East Anglia ONE North and East Anglia TWO Offshore Windfarms

Applicants' Comments on Historic England's Deadline 11 Submissions

Document Reference: ExA.AS-15.D12.V1

Date: 28th June 2021

Figure: 8g
CHVP3: PROW between Moor Farm and Little Moor Farm

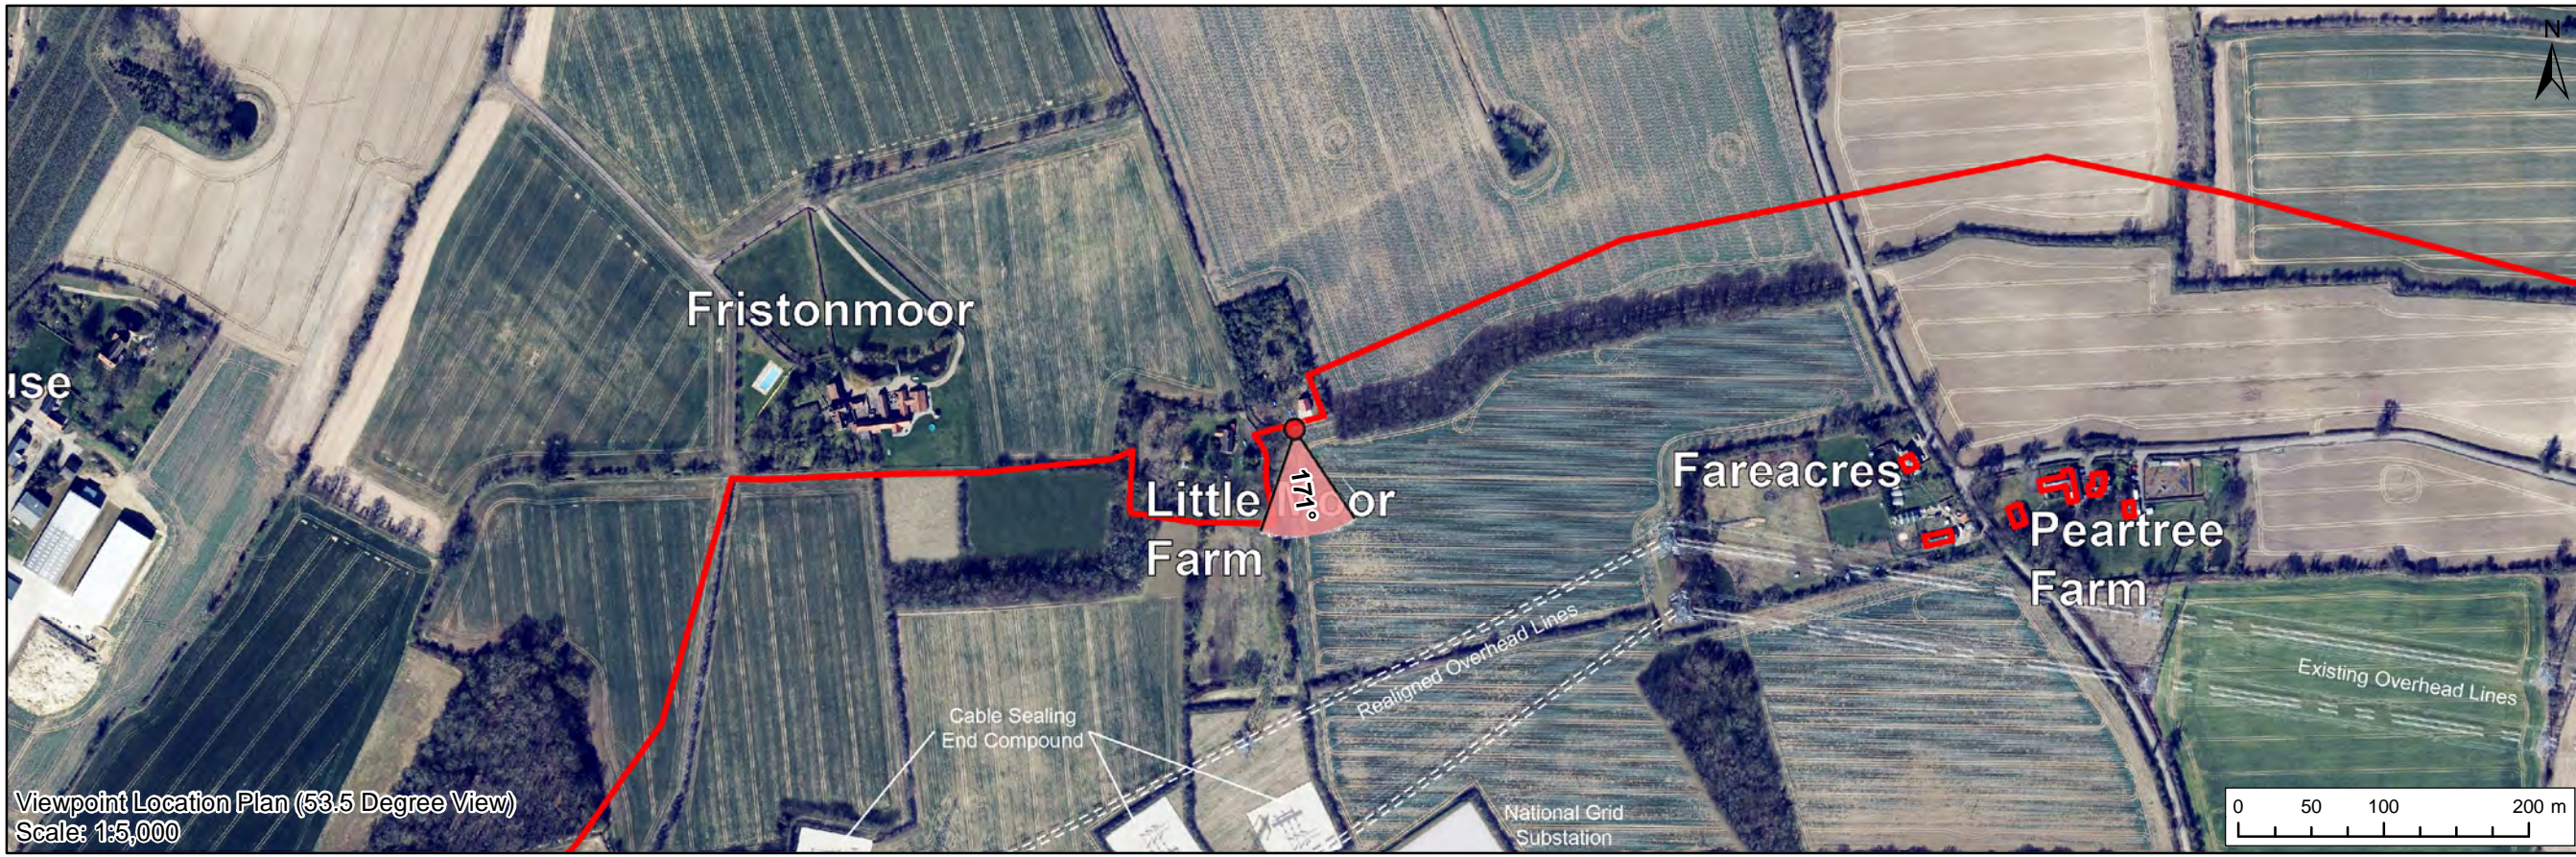
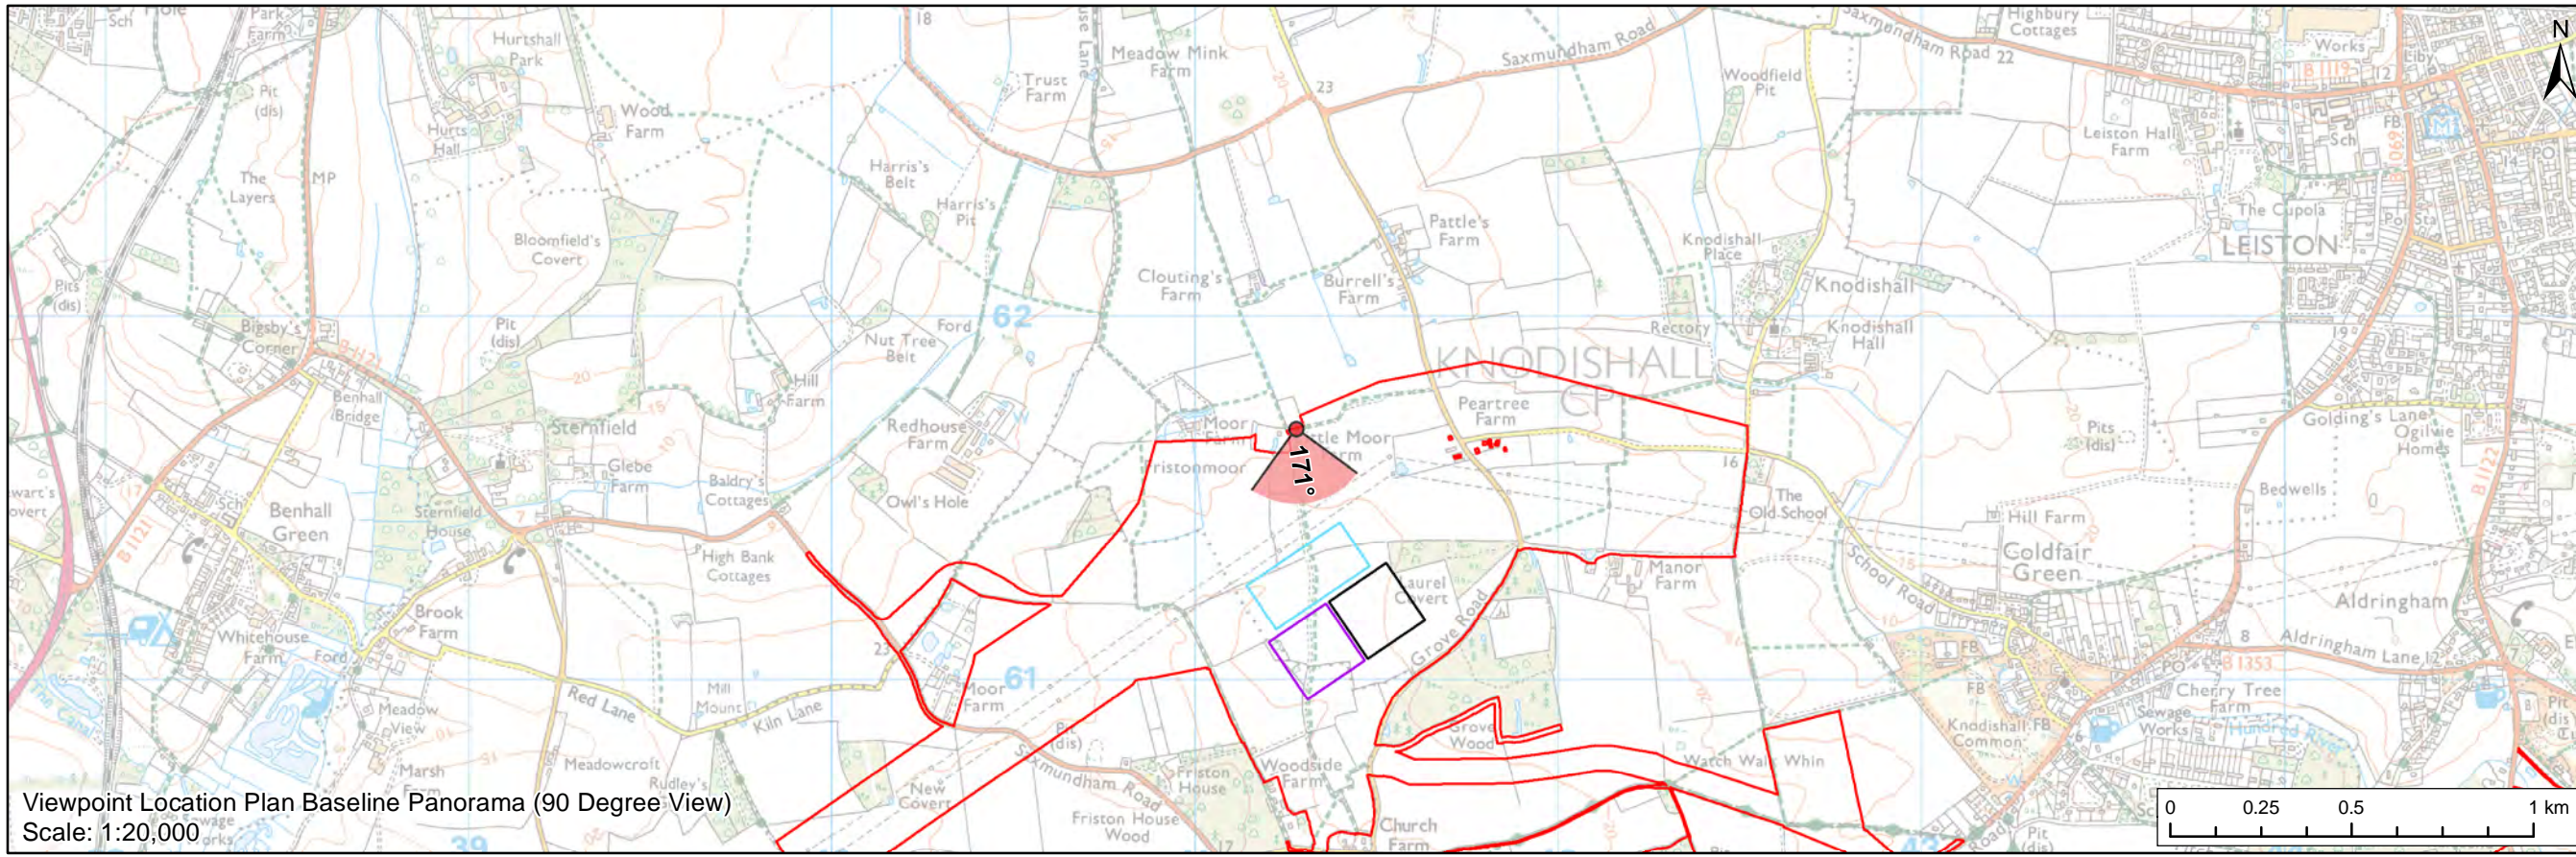
ID	ExA's Question	HE's Comment	Applicants' Comments
		<p>the church when moving south from Little Moor Farm to the village. It is its presence as a key marker, a historical landscape and as the dominant building in that landscape. We therefore consider this non designated asset to be an important feature that contributes to the significance of the Grade II* Church.</p> <p>Recognising this landscape feature as a non designated heritage asset has highlighted links with the church, and how this landscape makes a positive contribution to the significance of the Church. In our view, the greater knowledge and understanding does increase the significance of the church. We would defer to the council in relation to the other asset, however we acknowledge the value to the links between the farm and Church.</p> <p>In terms of impact we have noticed this elsewhere in previous letters, but the substation would be built across this boundary. It would sever it and remove an entire section. This would result in a direct physical impact upon the asset itself. We are conscious that the development would also erase the historical route between Little Moor Farm and Friston Moor and the village and would required a diversion of the right way which has also survived along this boundary.</p>

ID	ExA's Question	HE's Comment	Applicants' Comments
		<p>The scale and size of the development would deprive the church of its northern setting and would sever the relationship between the land to the north and the church. It would erode the rural context and remove any 'experience' of the church from the land to the north, and from this historic routeway and footpath. We have also set out this issue in previous advice.</p> <p>We have reassessed this in light of the question set out above and concluded this development would result in a severe harm to the non designated asset and we remain of the view that it would result in a very high degree of harm to the designated church. Our position remains unchanged, although we acknowledge that a great understanding of the boundary does contribute more to our understanding and experience of the church and increases the contribution this land makes to the church's significance</p> <p>We continue to raise an in principle objection to the sub station element of the development. We remain of the view that heritage assets were not given due weight by the applicant in the site assessment process and therefore the contribution this land makes to the significance of the designated church was not fully considered.</p>
